# TECHNICAL MEMORANDUM

Date: September 20, 2019  
To: Richard Fisher, Fisher Architects  
From: Ryan Kahlo, PWS  
Project Name: Mercer Island Yang  
Project Number: 180605

## Subject: Response to September 2019 City Comments

MITIGATION PLAN

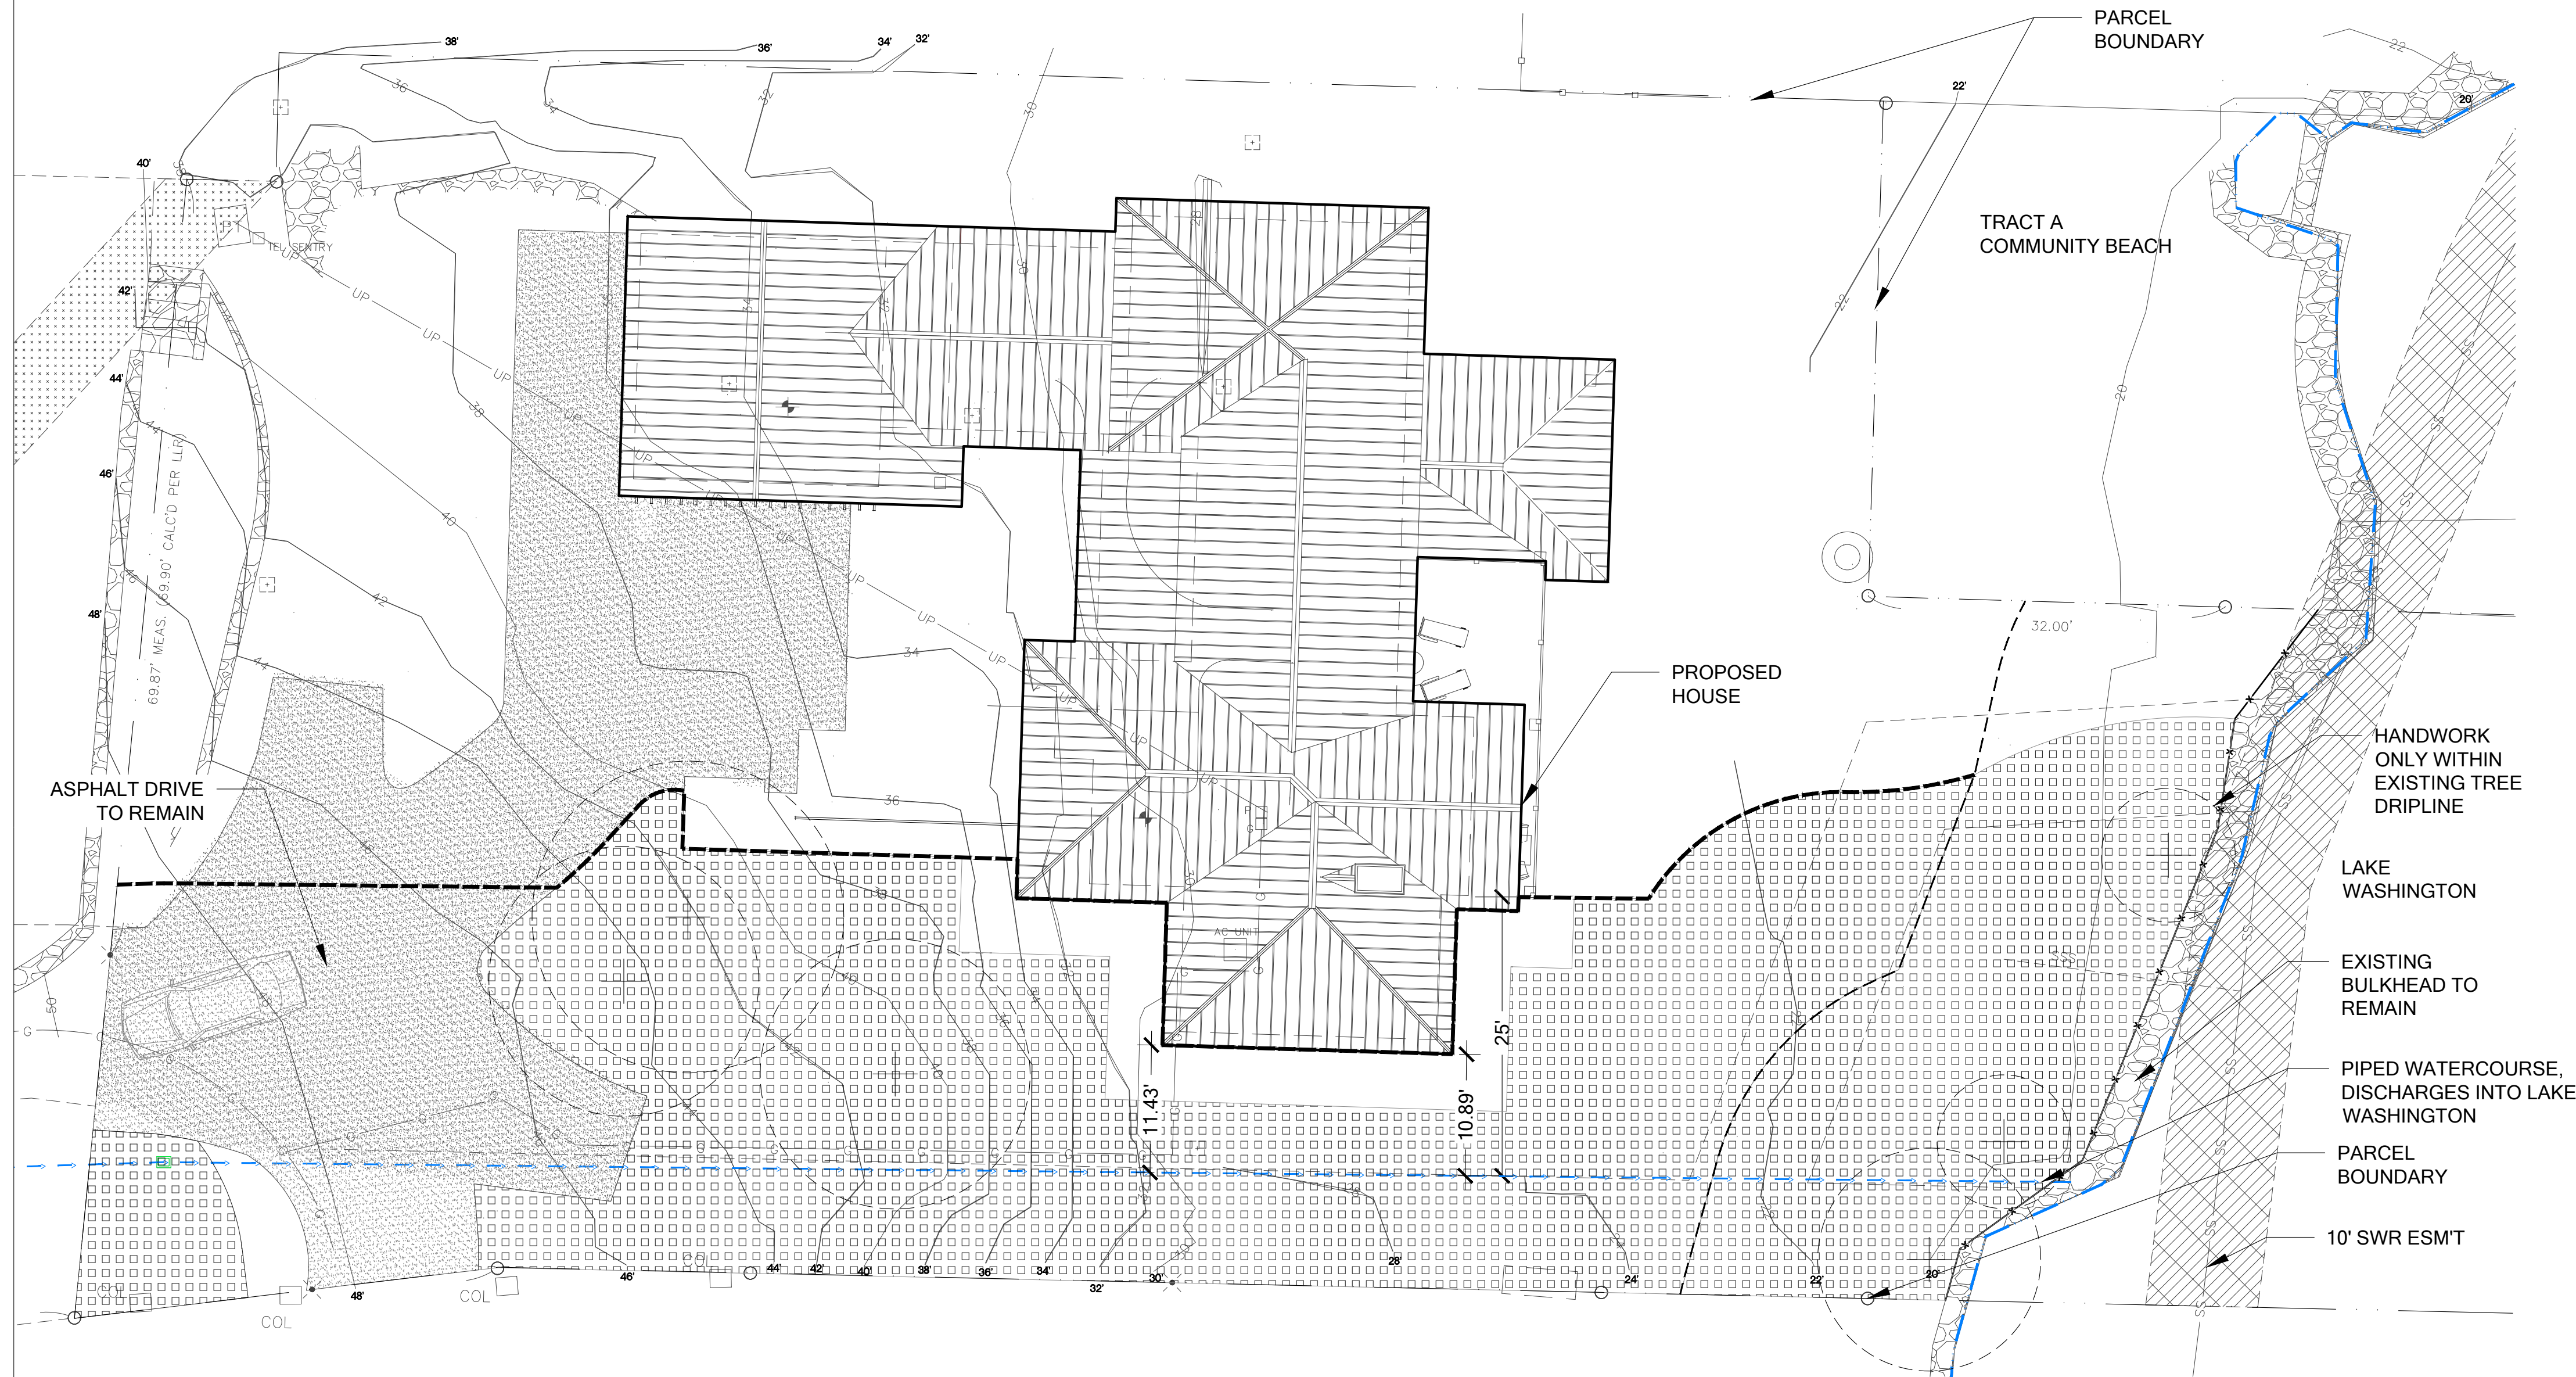
2. *The Critical Area Study proposes a 10.75-foot watercourse buffer, the RFA Architects Site Plans proposes a 10-foot watercourse buffer, and the mitigation plan proposes an 11-foot buffer. Any of these stated buffers could be in compliance with code, however a single minimum buffer distance should be stated.*

- 5. Please provide an updated Mitigation Plan once the proposed watercourse buffer distance is selected. Also, the existing rockery hardscape areas should not be included in the watercourse buffer enhancement area calculation.*

The precise location of the proposed residence from the piped watercourse varies slightly in different locations due to the angle of the new residence. The proposed buffer width along the south side of the new residence (at the closest points) ranges from 10.89 feet to 11.43 feet.

The variable width is depicted on the revised mitigation plan accompanying this memo. The setbacks depicted on the architectural site plan are not related to the watercourse buffer.

A revised mitigation plan has been provided. The "rockery hardscape areas" are not rockeries. They are individual stones that function as landscape borders in the existing configuration. These features will not be present in the buffer enhancement areas and have been removed from the revised mitigation plan.

PLANTING PLAN
SCALE: 1" = 10'-0"

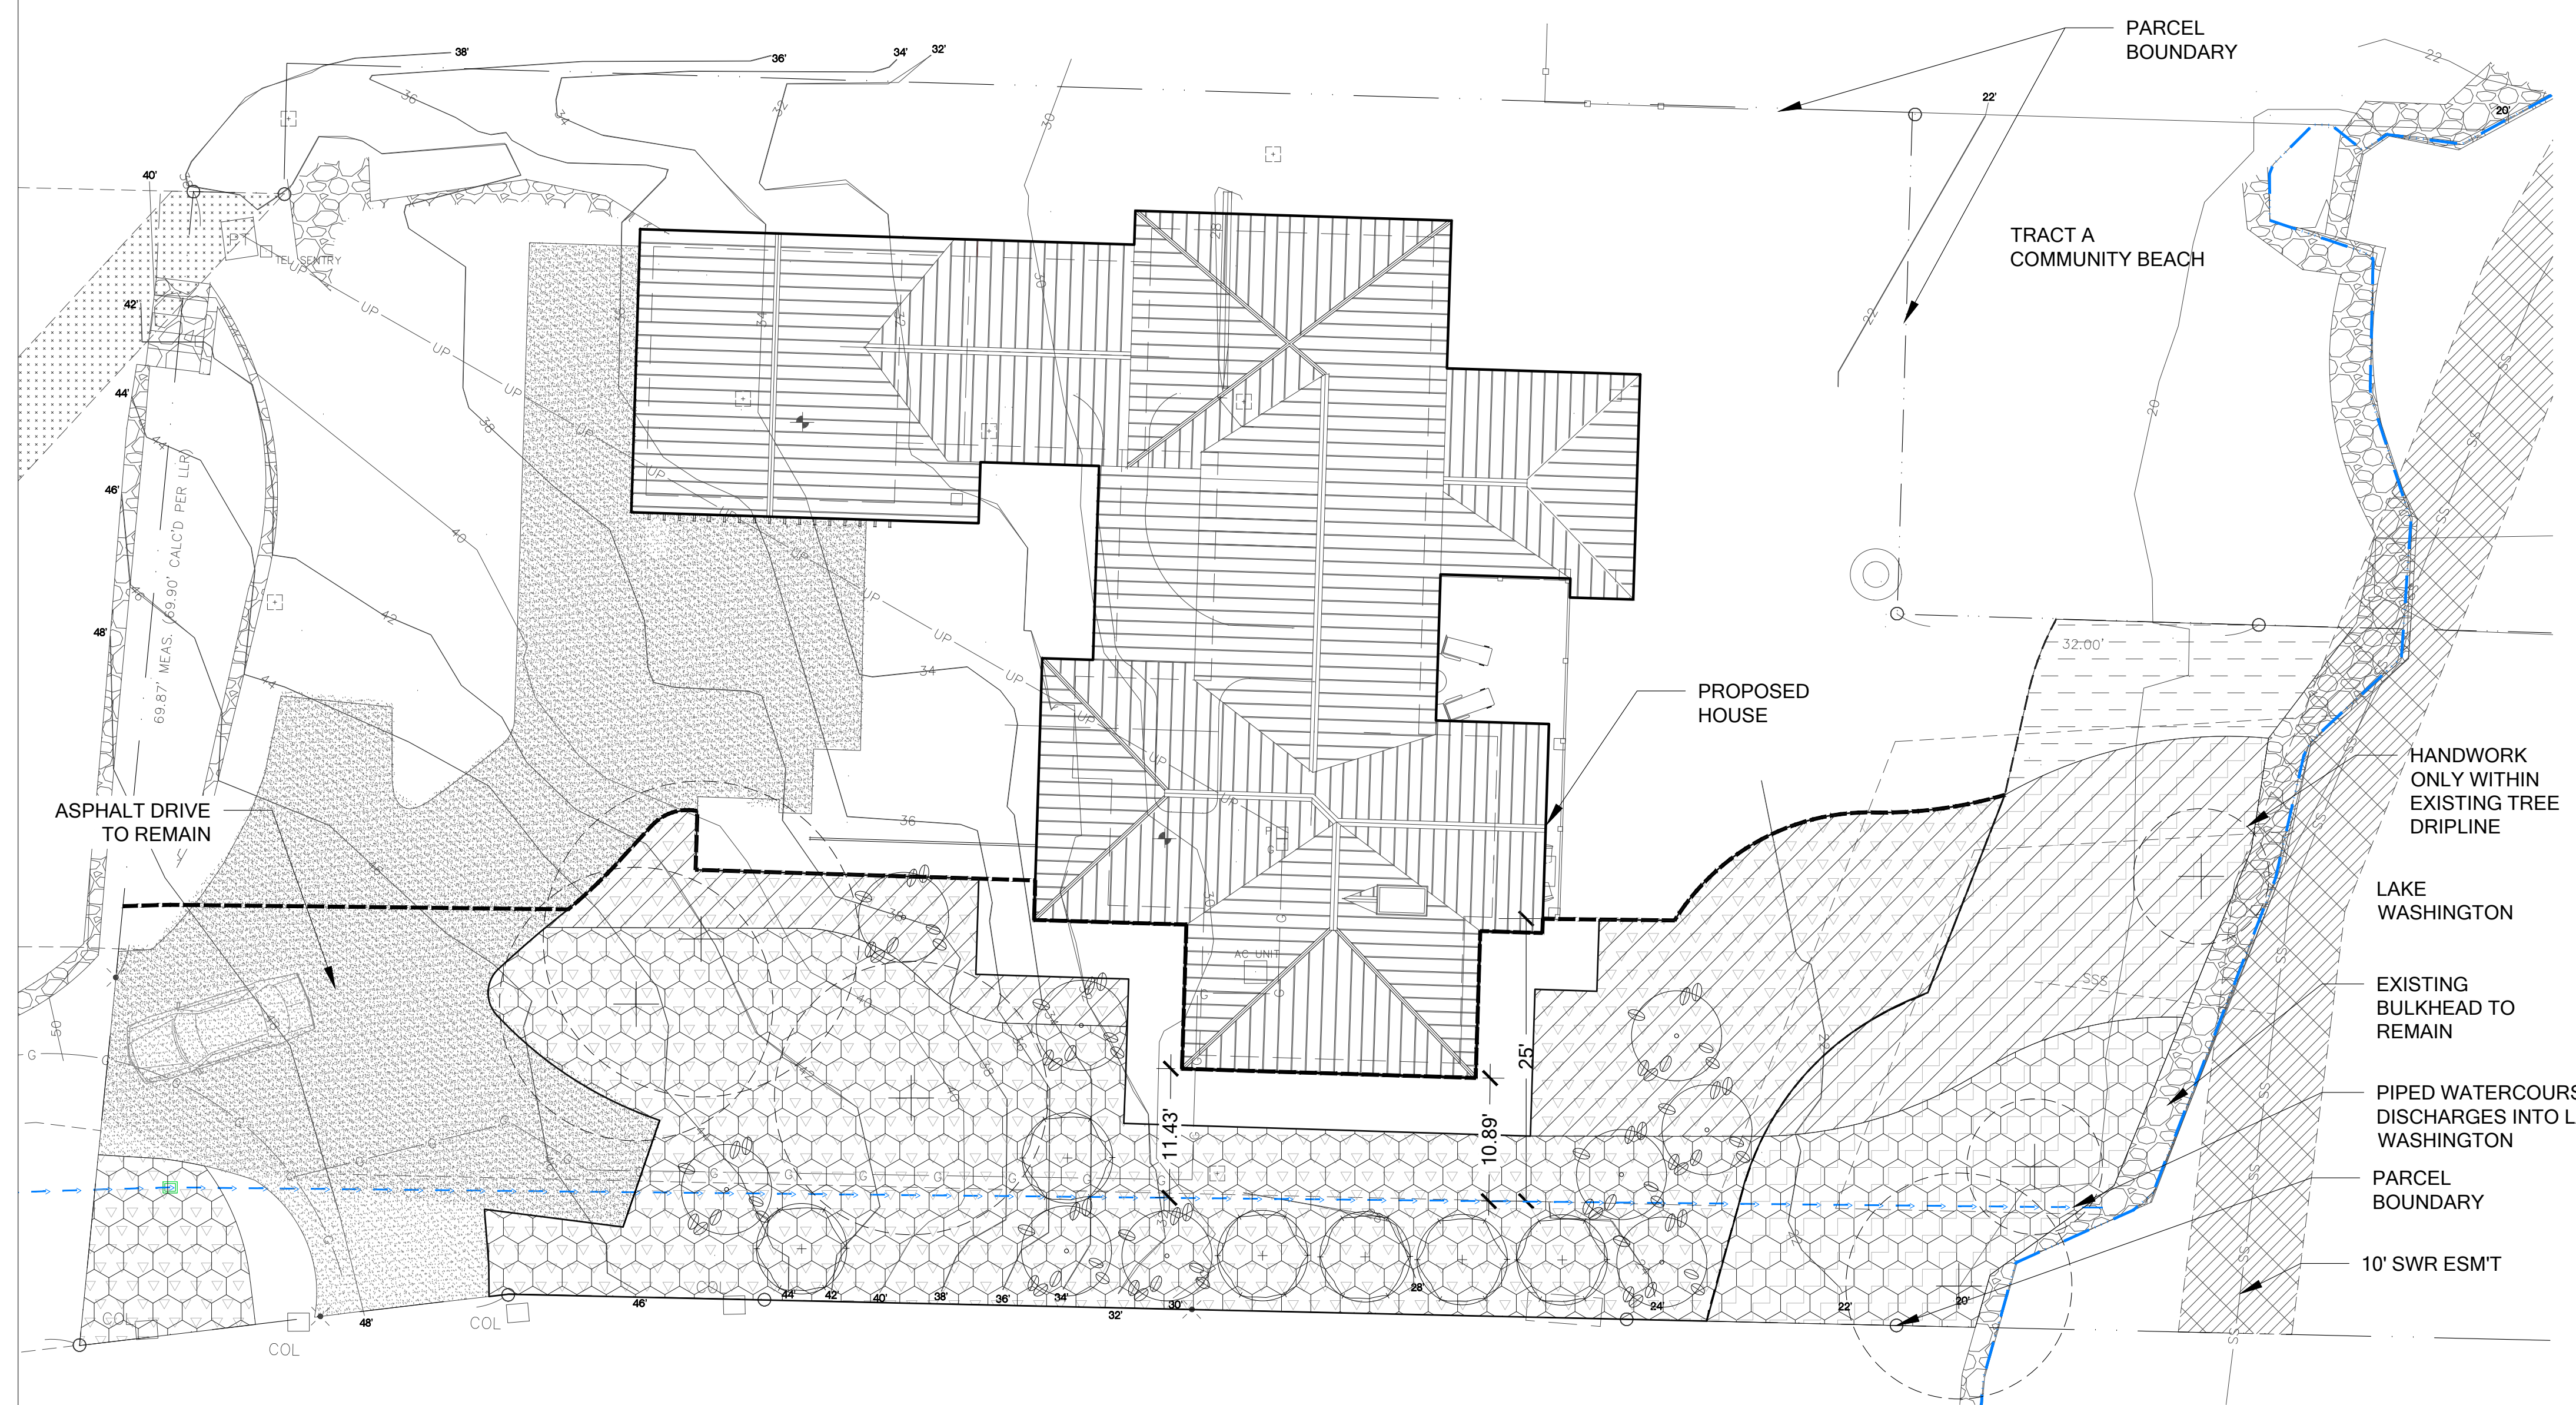
- 3. The Critical Area Study states "The entire averaged buffer will be planted with native vegetation". However, the Buffer Averaging plan set shows a 5-foot unplanted setback area around the residence leaving a 5 to 6-foot piped watercourse buffer enhancement area. Please clarify the proposed minimum piped watercourse buffer and update the Buffer Reduction plan set based on the proposed buffer.*

- 7. It appears as though the proposed native vegetation plantings along the shoreline meet or exceed 75 percent cover in the area within 20 feet of the Lake Washington Ordinary High Water Mark, consistent with the Shoreline regulations. Please provide calculations of planting areas to demonstrate the 75 percent cover requirement is met.*

The entire averaged buffer will be enhanced with native vegetation. The hatching depicting the enhancement area shows where the plantings will be planted. Since the plantings are to be installed on four- to six-foot on-center spacing, cover from the installed shrubs will extend beyond the hatching towards the residence. It is not appropriate to install shrubs right up the edge of the new residence. The "5-foot unplanted setback area" is part of the regulated buffer; it will have at least partial woody cover; no structures or impervious surfaces are allowed or proposed in that area. The relocation of the house farther from the watercourse and the extensive enhancement across the site ensures the averaged buffer will function at a substantially higher level than the existing buffer.

The total shoreline setback area on the property is 1,627 square feet. The shoreline setback enhancement area is 1,350 square feet. The enhancement area is equivalent to 83 percent of the total shoreline setback area.
